8th June 2017

Demolition of 1 No. shed & garage & erection of two storey side extension, driveway & entrance gates.

14B Sea Way Middleton on Sea

Planning Application - M/42/17/HH 14b Sea Way

Proposed Front Elevation
Scale - 1:100

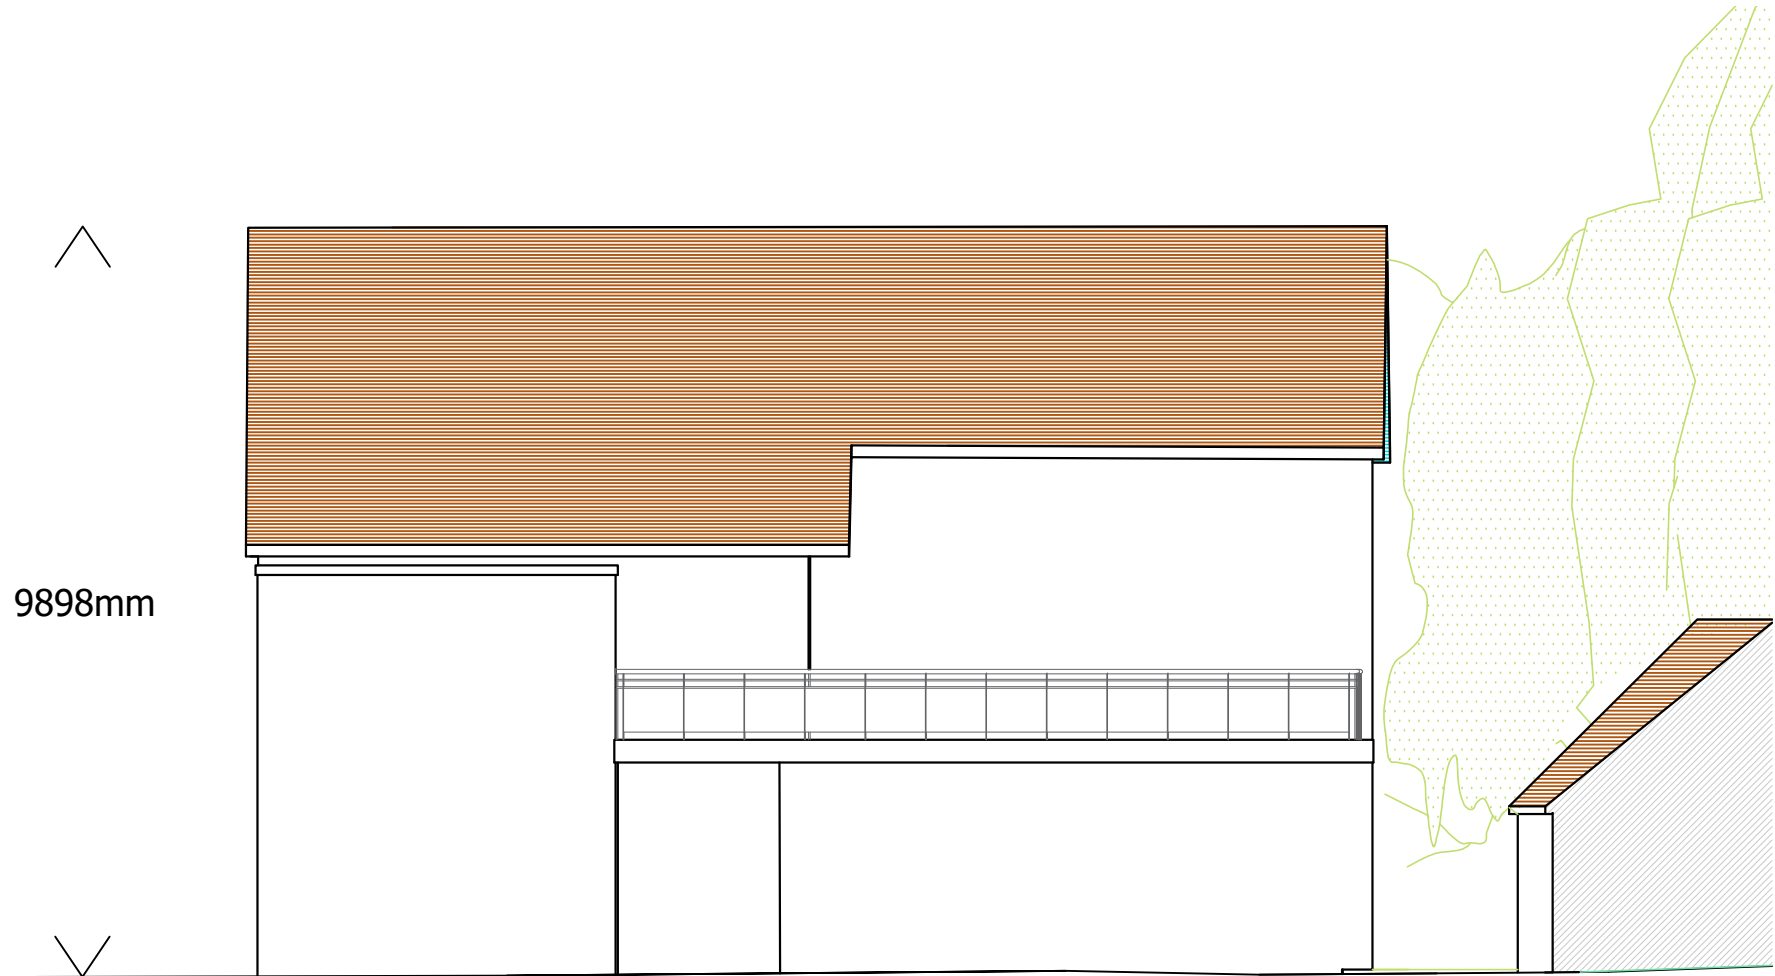
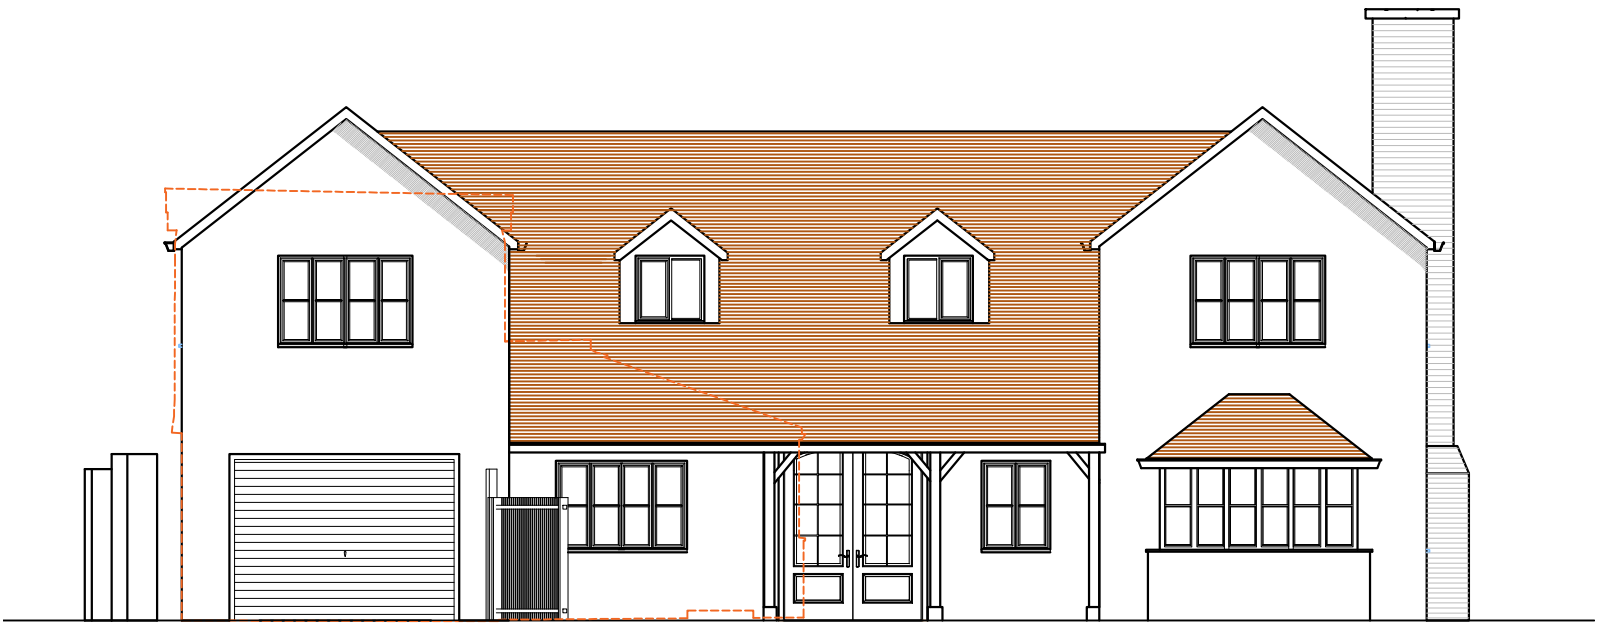
The existing building is unattractive and previous plans have been to demolish it. This latest application is to use it as the basis to build an "extension" which would quadruple its size and with a pitched roof increases the height of the building. The building would dominate the outlook from our house.

The overall mass, height and scale of the proposal would be:

- *overdevelopment of the site*
- *unneighbourly*
- *detrimental to the living conditions, amenities and privacy of nearby residents*

GROUND FLOOR

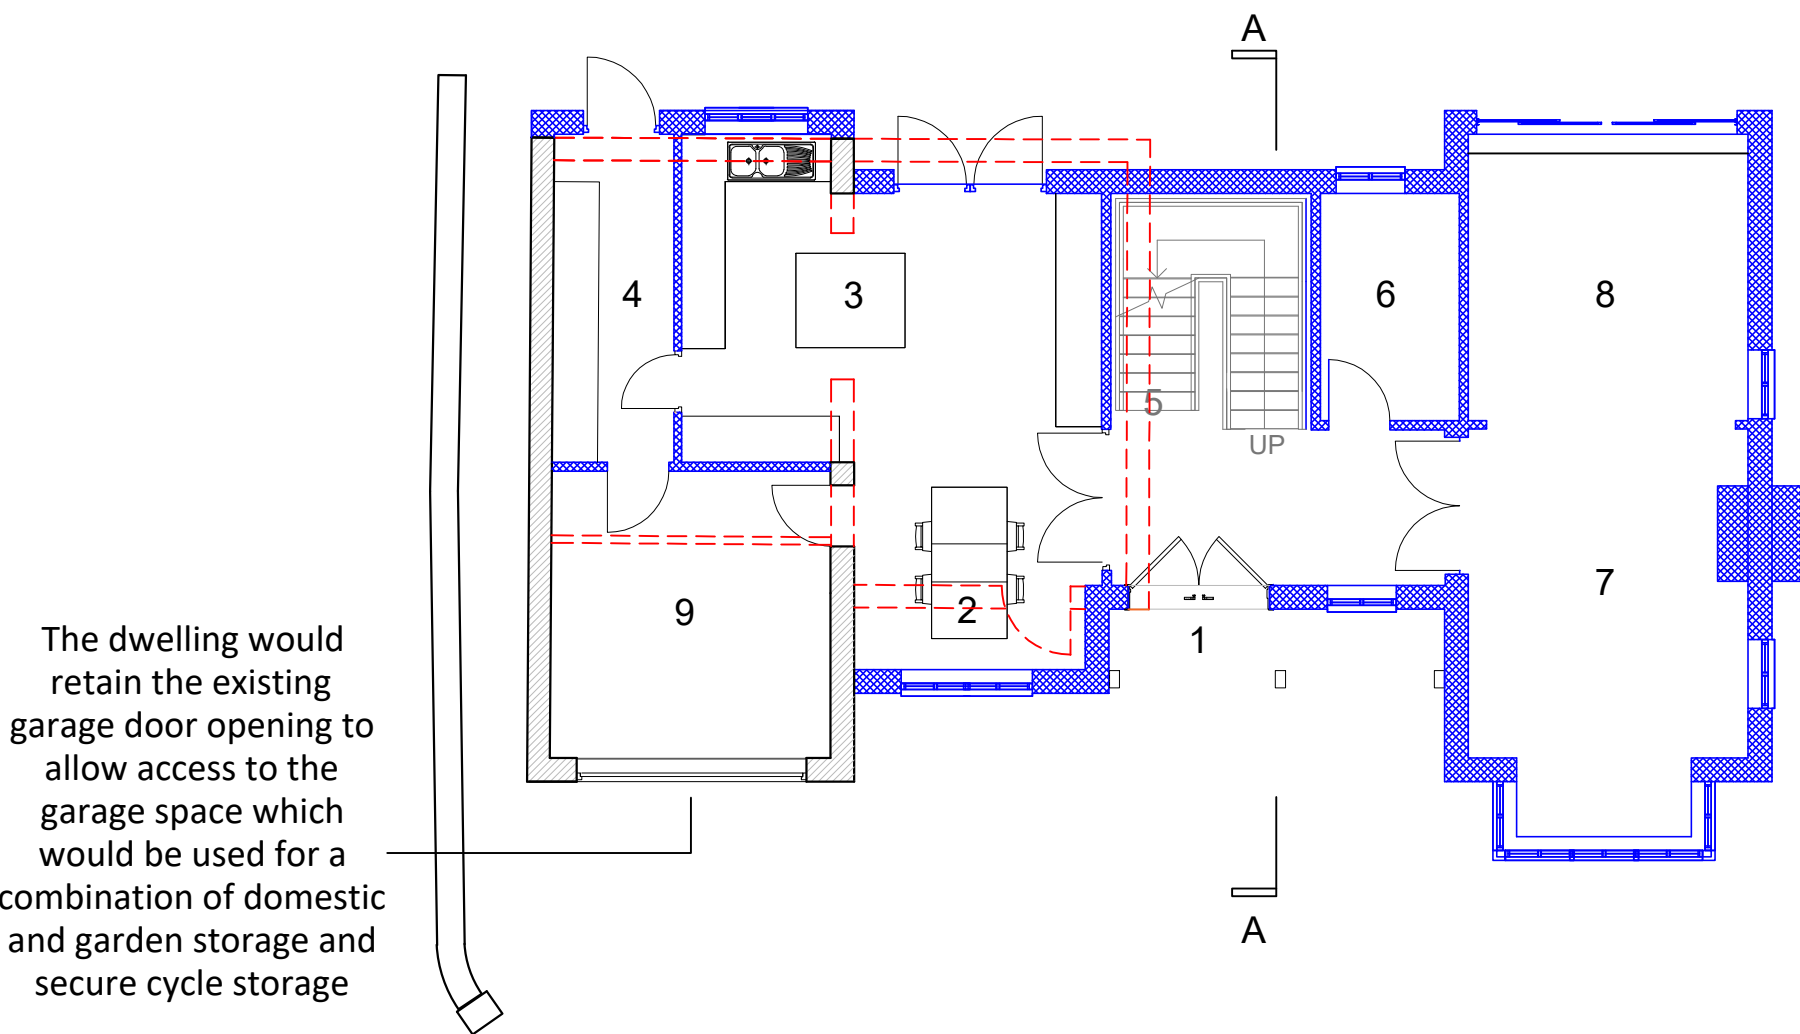
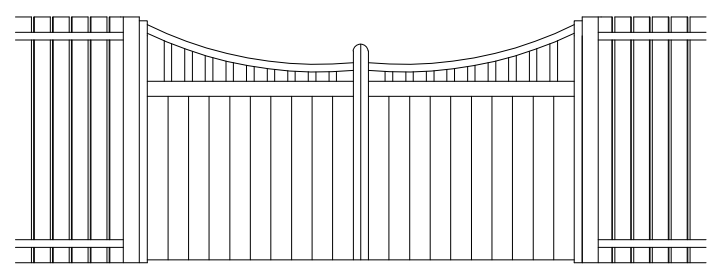
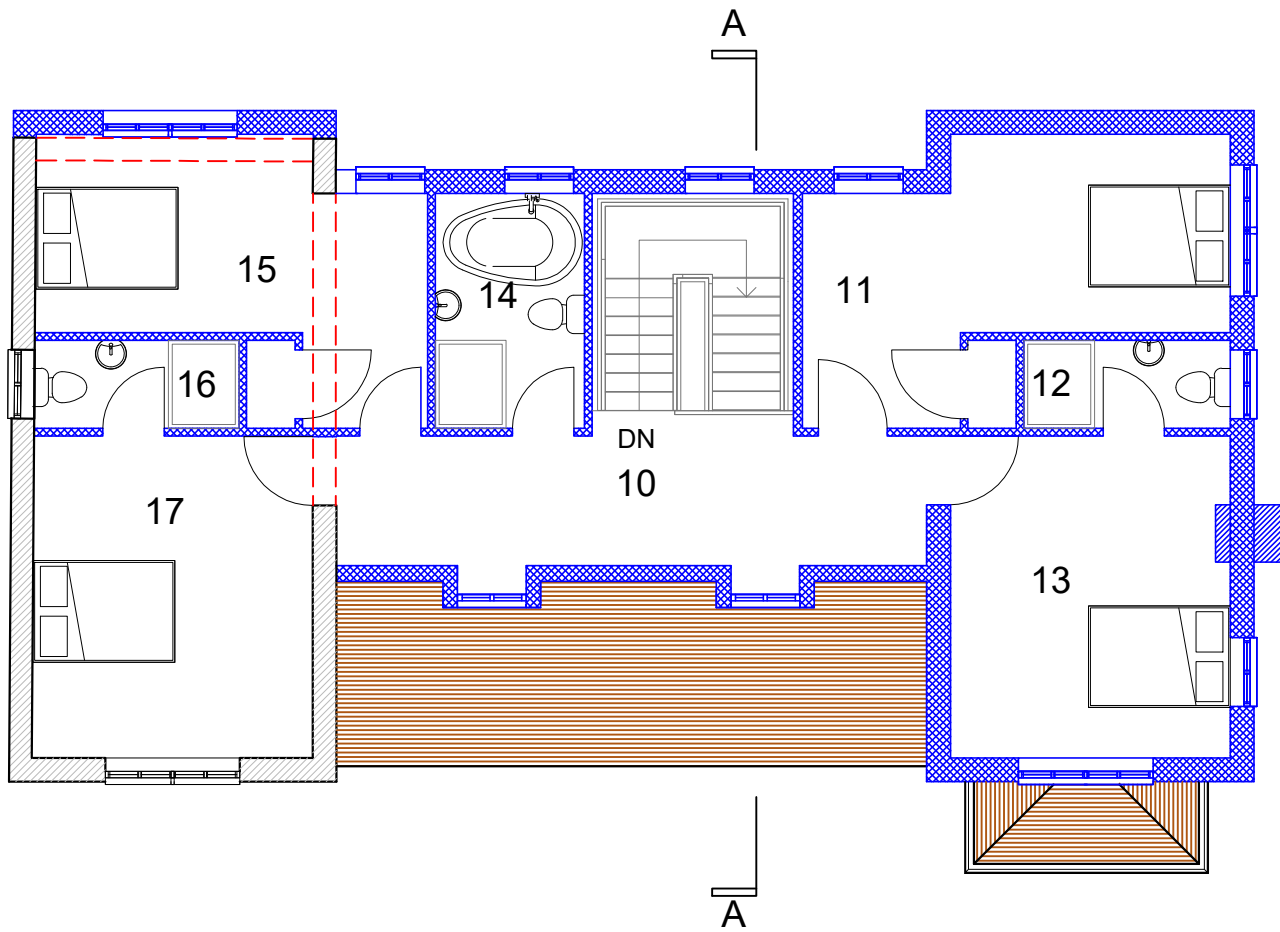
The latest application is for a different design but it is still a large four bedroom house which will overlook our property and that of our neighbours.

The proposal cannot be considered as an extension, given the scale of the increased size. The idea that demolishing the garage and a small shed could offset the development in any way is compromised by the recent building of a brick construction garden room, which is described as a shed on the plans, and is of similar size to the double garage to be demolished.

Site Plan
Scale - 1:500

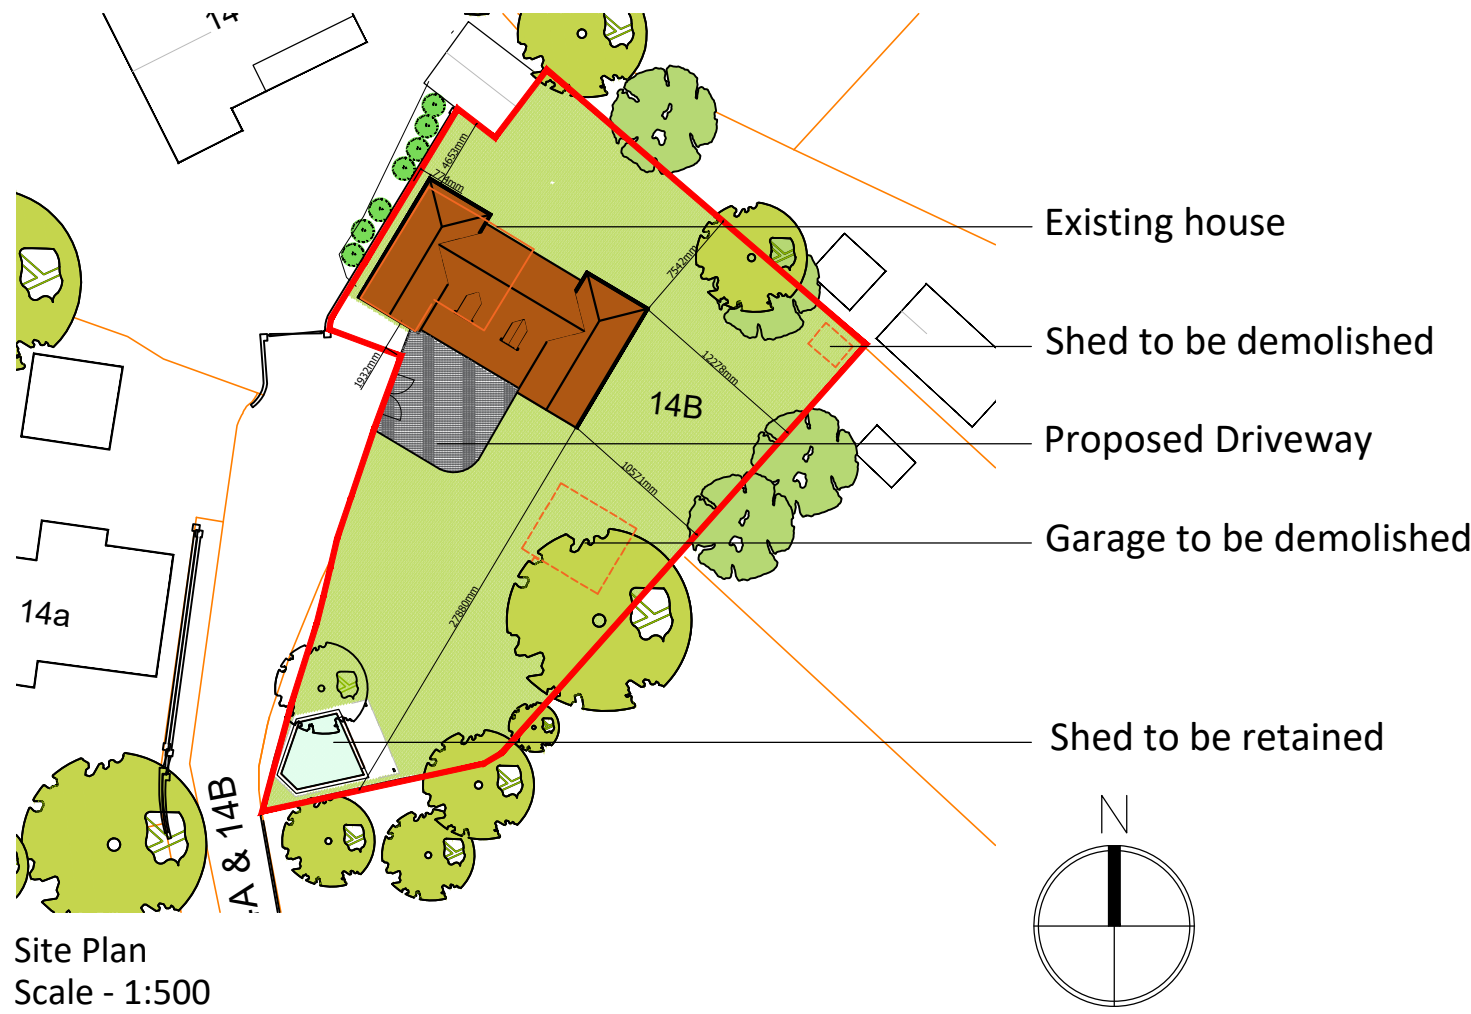
The limited space for parking and turning will result in the use of the shared drive for

parking leading to further inconvenience to other residents.
